**From:** [REDACTED]  
**To:** [M42 Junction 6](#)  
**Subject:** Response to the Examining Authority's Draft Development Consent Order Commentary Schedule of Changes - Issued 8th November 2019  
**Date:** 15 November 2019 20:09:50

Heath Cotterill

Interested Party Ref: 42J6-S57005

**Indicative Proposal for Main Compound  
and Office for M42 J6 Scheme**

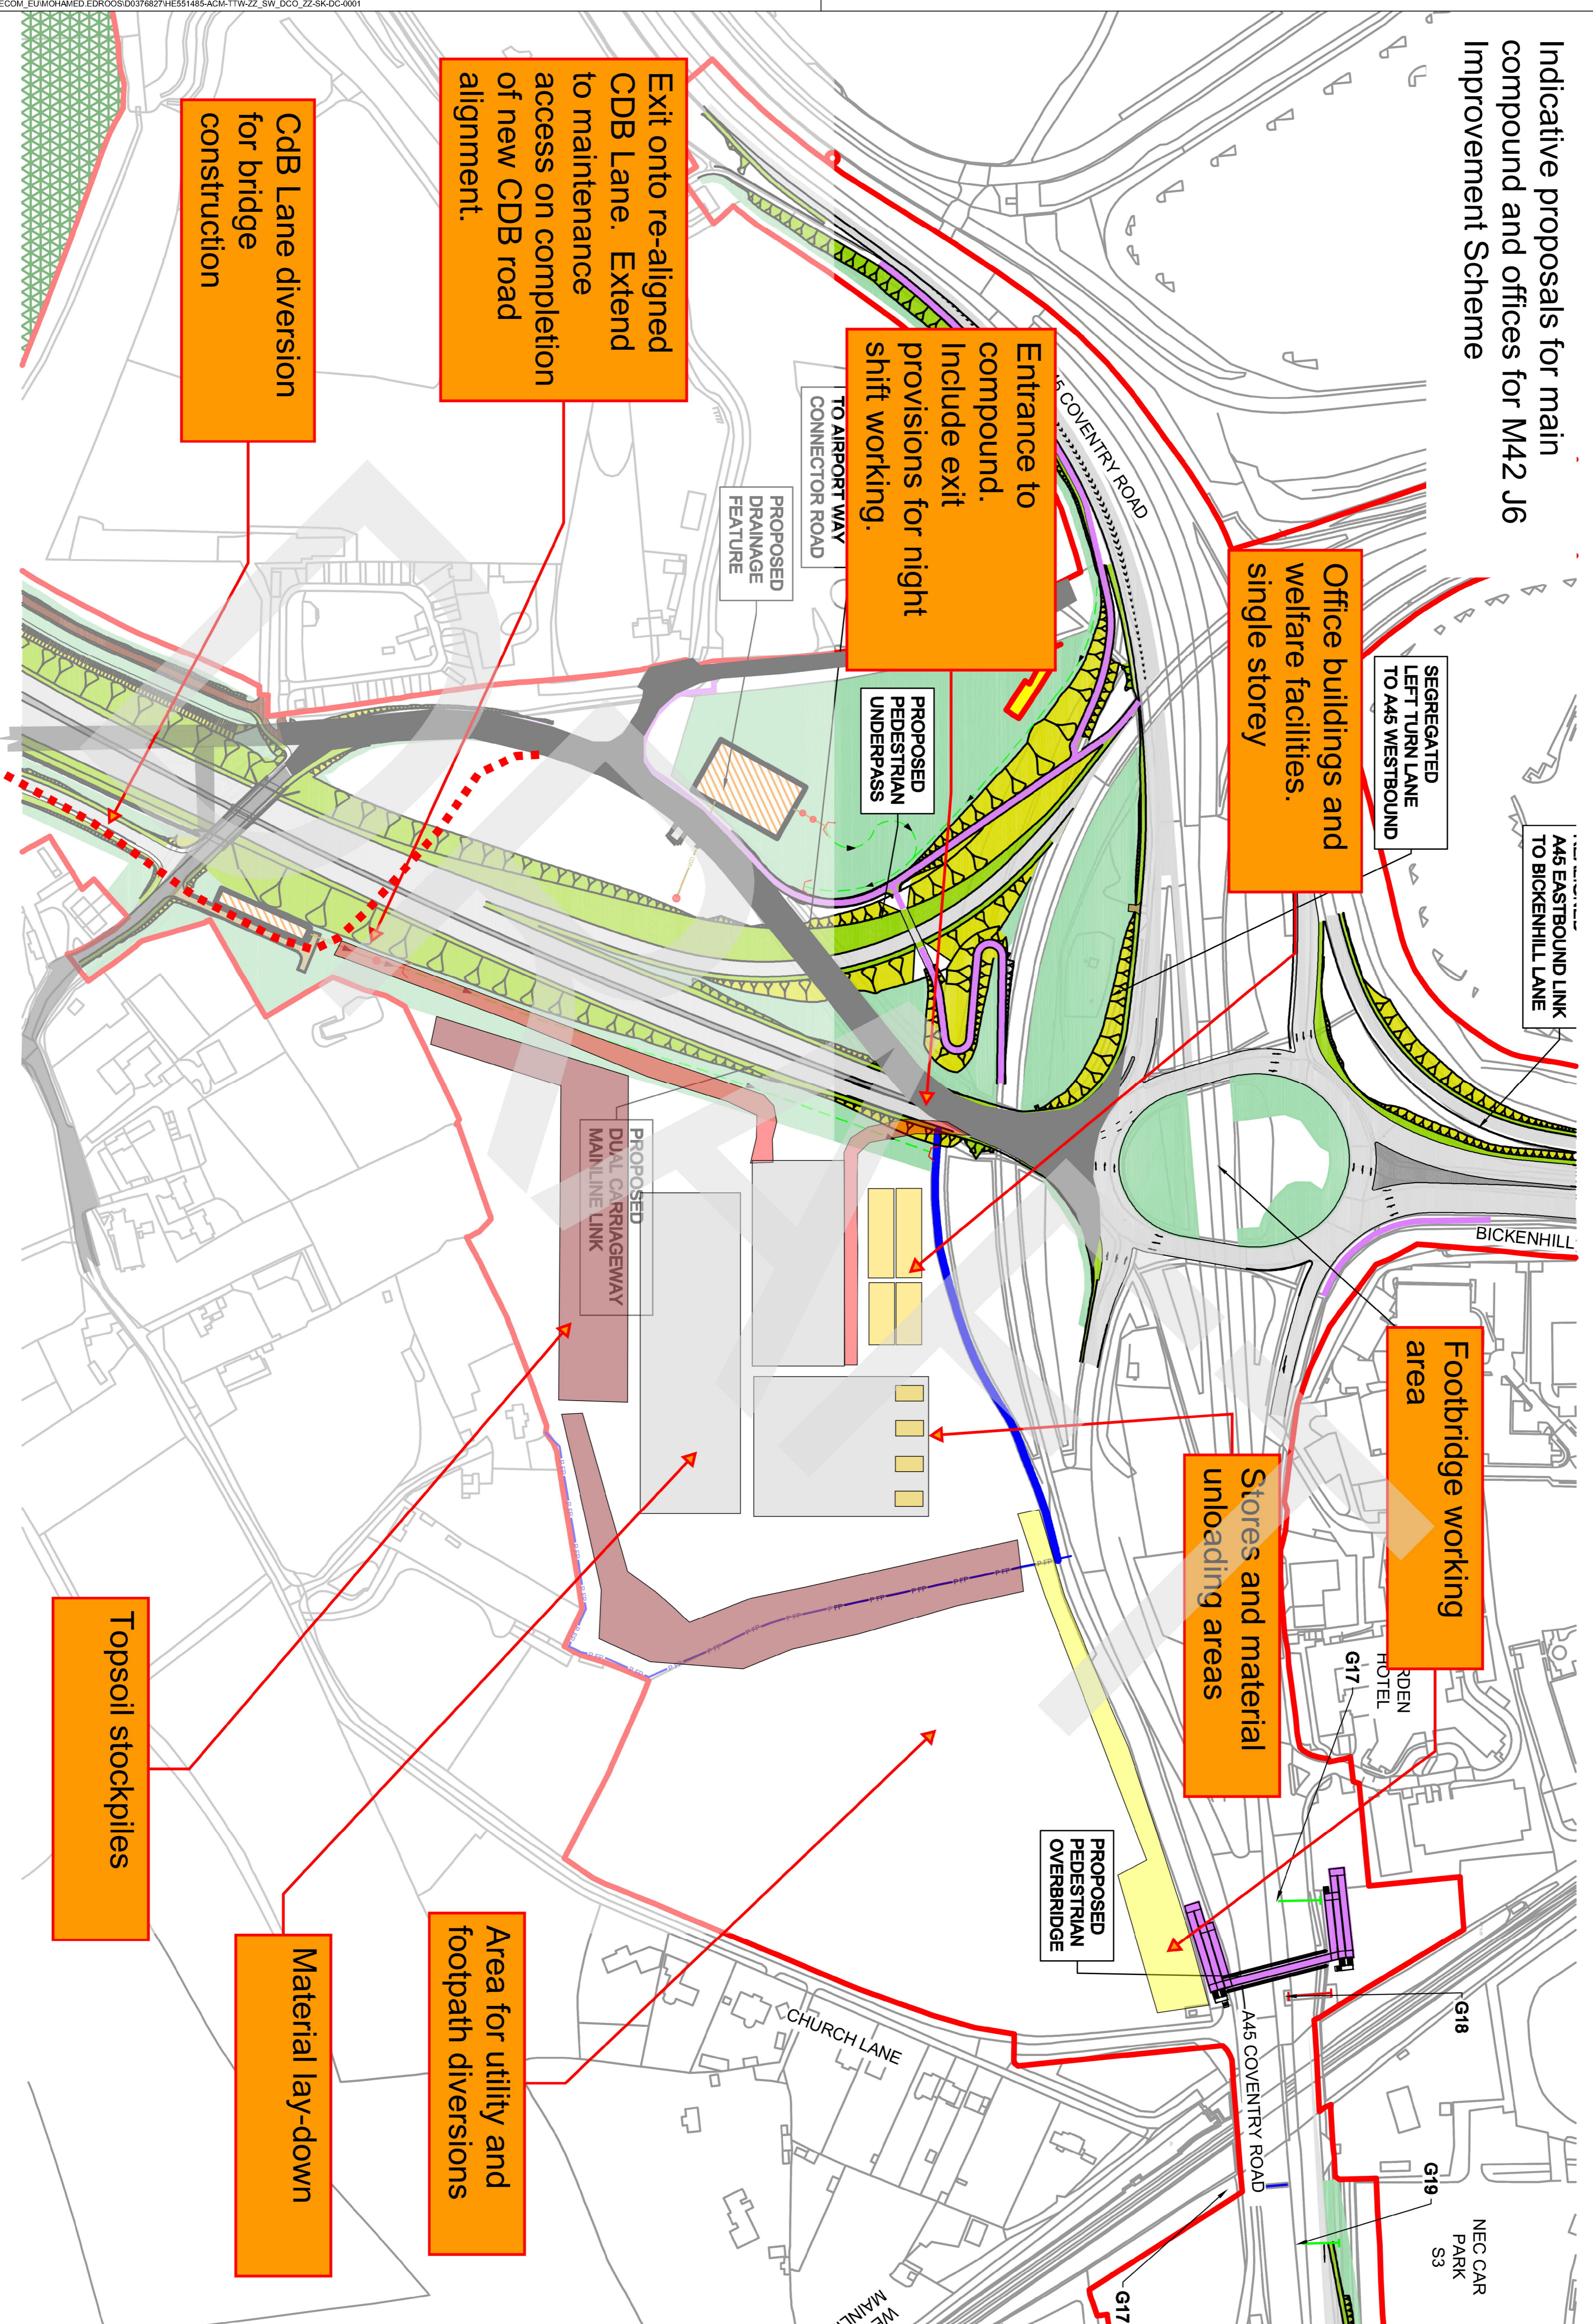
**Commentary:** The ‘Indicative Proposal for Main Compound and Office for the Scheme’ replicates the initial arrangement set out at D3A [REP3A-003] rather than the alternative

configurations put forward at D6 (REP6-015 – page 13) and D7 (REP7-011 – Appendix 1, Page 2 of 2). It was agreed that an alternative configuration was possible with an entrance and exit onto Catherine-de-Barnes Lane at the northern end of the compound (Figure 1 at Action No.4 of REP6-015). Moreover, a plan at page 13 in the same section of the same document details how the compound could be reconfigured to the north and east to increase the buffer significantly between the compound perimeter and the adjacent properties on Church Lane. Although the laydown areas would then be closer to residents at the north east of Church Lane, they would be screened by existing trees and hedgerows and the proposed stockpile bunds as shown in the cross sections on page 2 of Appendix 1 of REP7-011. The ExA recognise that this configuration might require a right turn from the northern exit to be prohibited and the installation of traffic lights there and additional phases in constructing the main line link road. However, the scale of the embankments and earth moving required for the scheme suggested in EV-040 could be prohibitive.

**RESPONSE:** My understanding was that if it had not been possible to relocate the main site compound then it would be reconfigured further north & east and I concur with the Examining Authority that the reconfigured plan with

**entrance and exits at the northern end of the compound onto Catherine de Barnes Lane would be much more preferable and less intrusive. The reconfigured entrance and exits would also negate the need for the construction and use of a temporary road in the field on the main site compound to the east of Catherine De Barnes Lane.**

Substitute the existing Plan at Appendix 1 of the Outline Compound Management Plan [REP8-009] with the plan shown at Action No.4 of REP6-015 (page 13) detailing how the compound could be pushed further to the north and east to increase the buffer and as also shown in the cross sections on page 2 of Appendix 1 of REP7-011.
